MEMORANDUM

SUBJECT: Duncanson Co SEG-06-115, 19-18-32000-0019

SUBJECT: Duncanson Segregation (File # SEG-06-115)

DESCRIPTION: Segregation of a 211.25 acre parcel into 10 parcels ((8) 20, (1) 00.76 and (1) 28.49 acre lots)

RECORD OF SURVEY

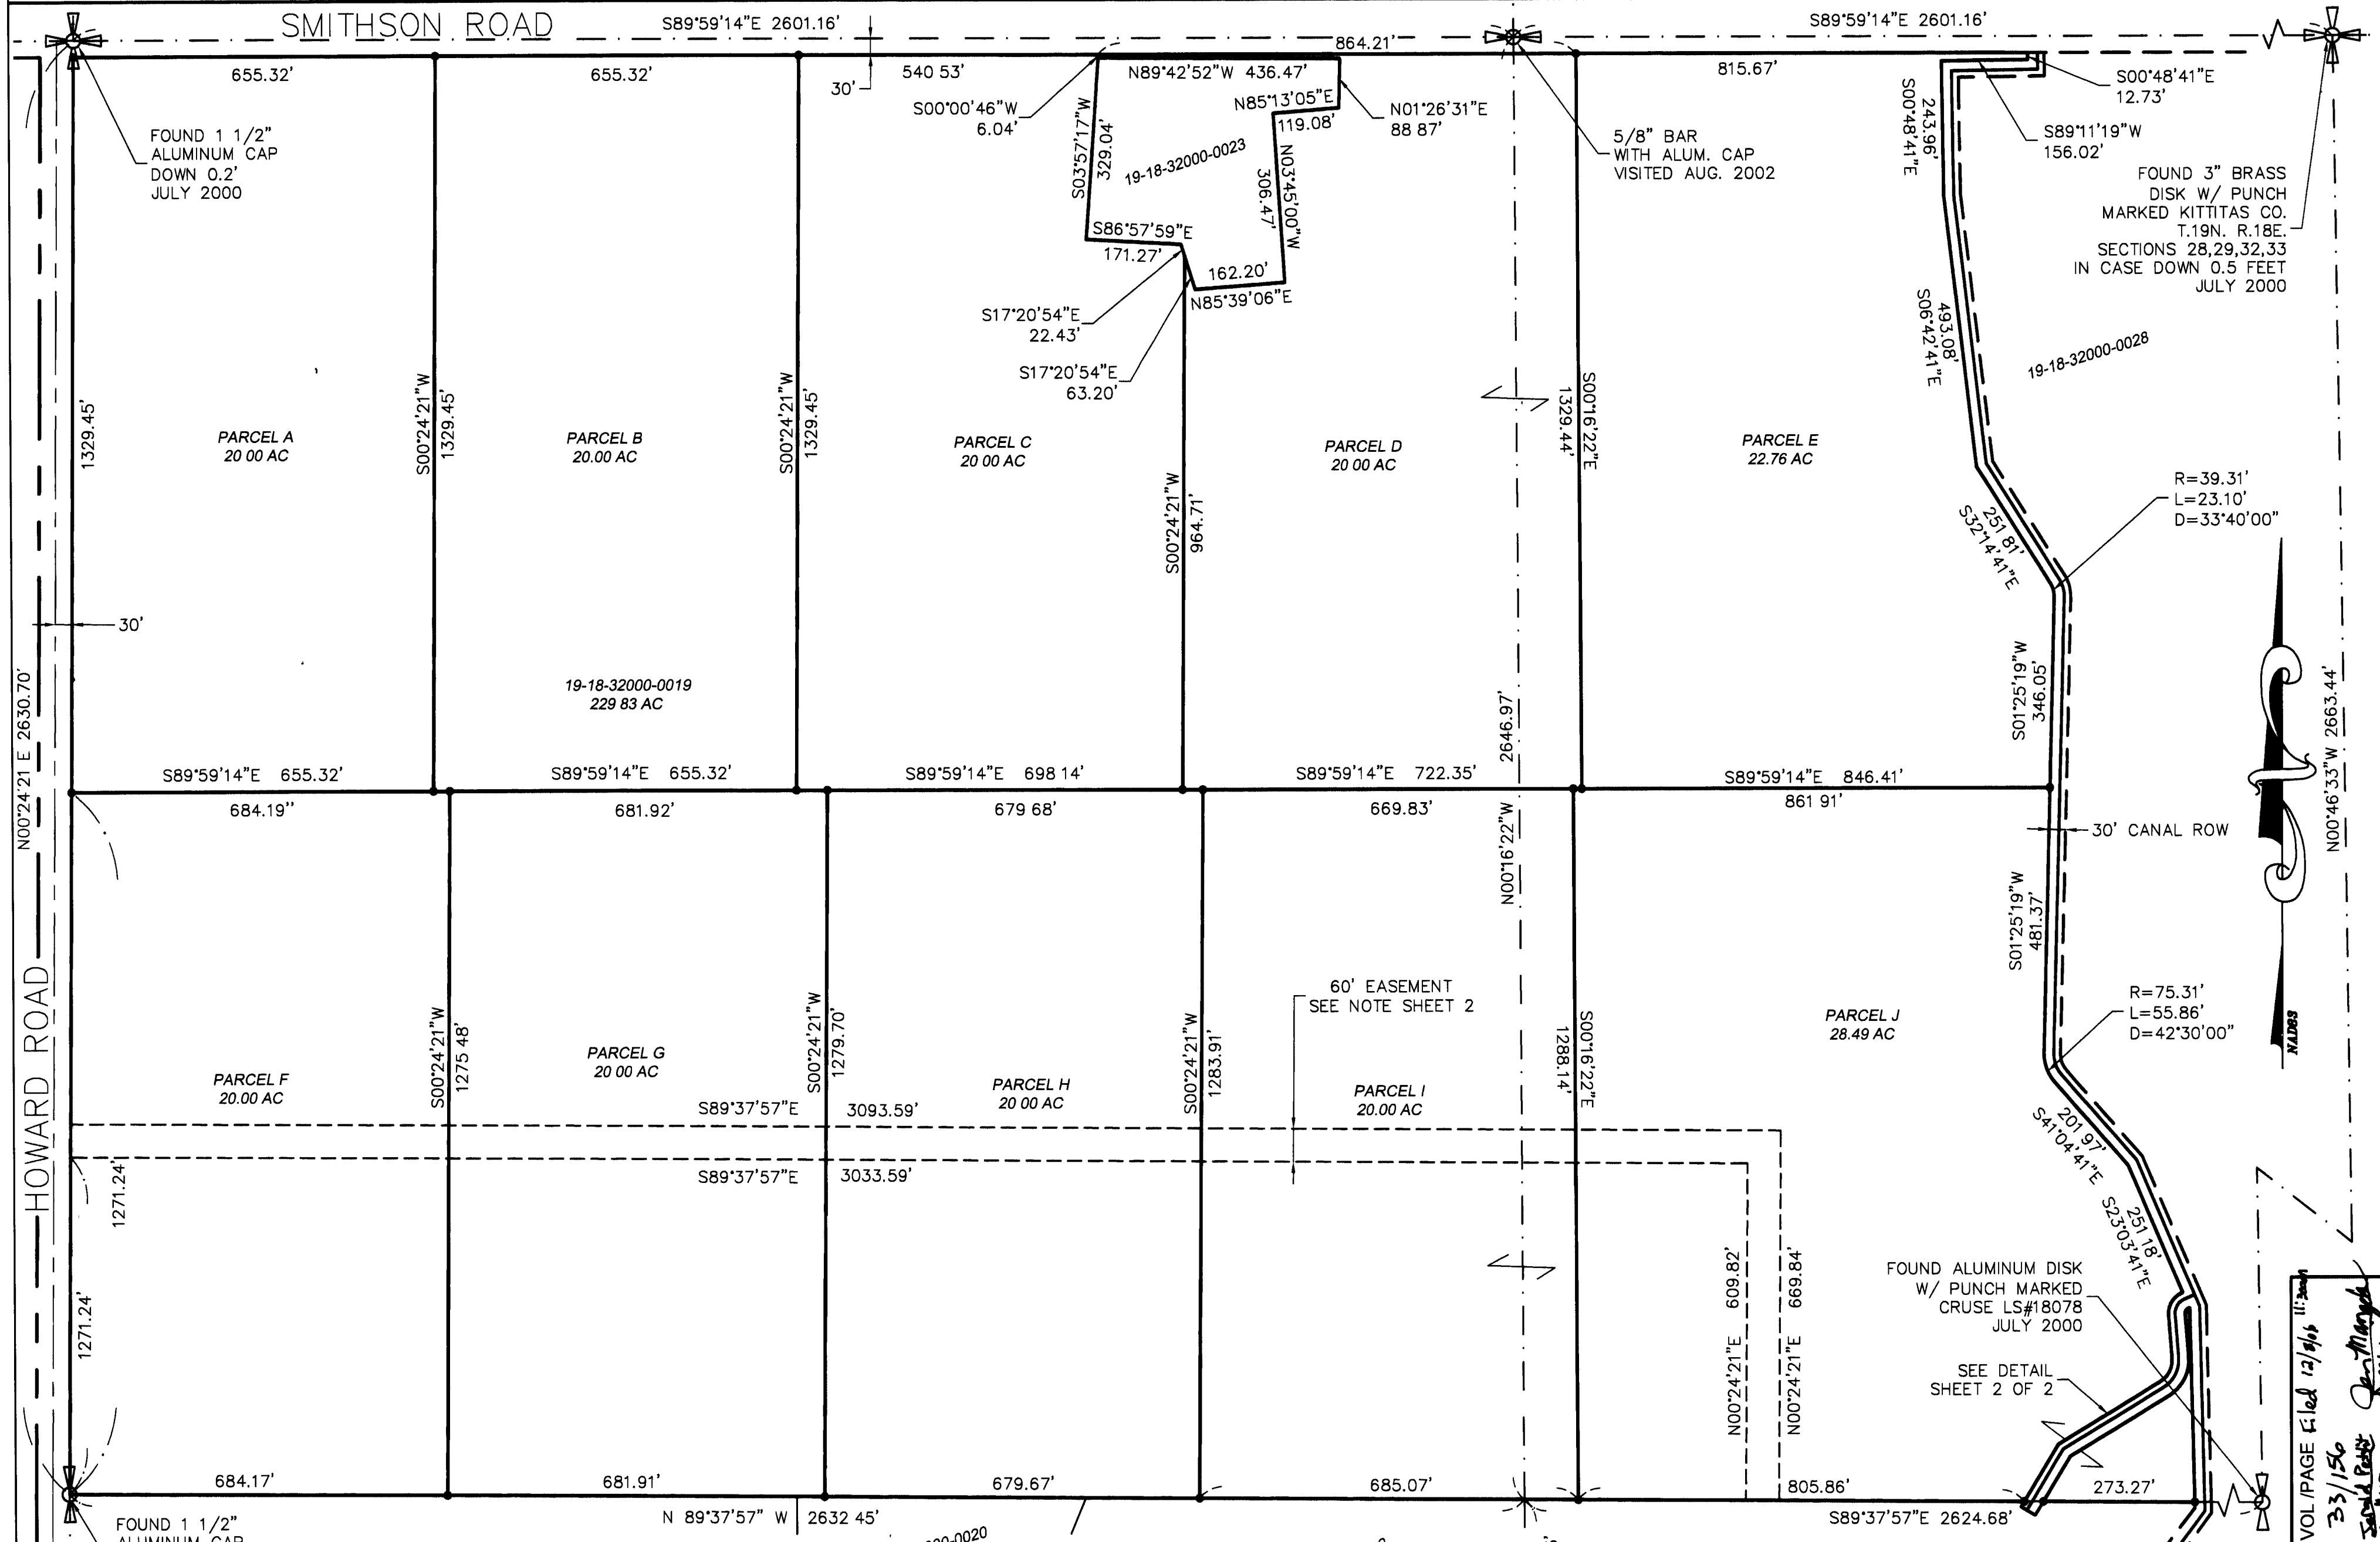
1. Prior to final approval the proposed access with appropriate easement(s) shall be shown and shall conform to applicable Kittitas County Road Standards.

1. Our department has reviewed the Request for Parcel Segregation Application and finds that it meets current Kittitas County Road Standards. **Our department recommends Final Approval.**
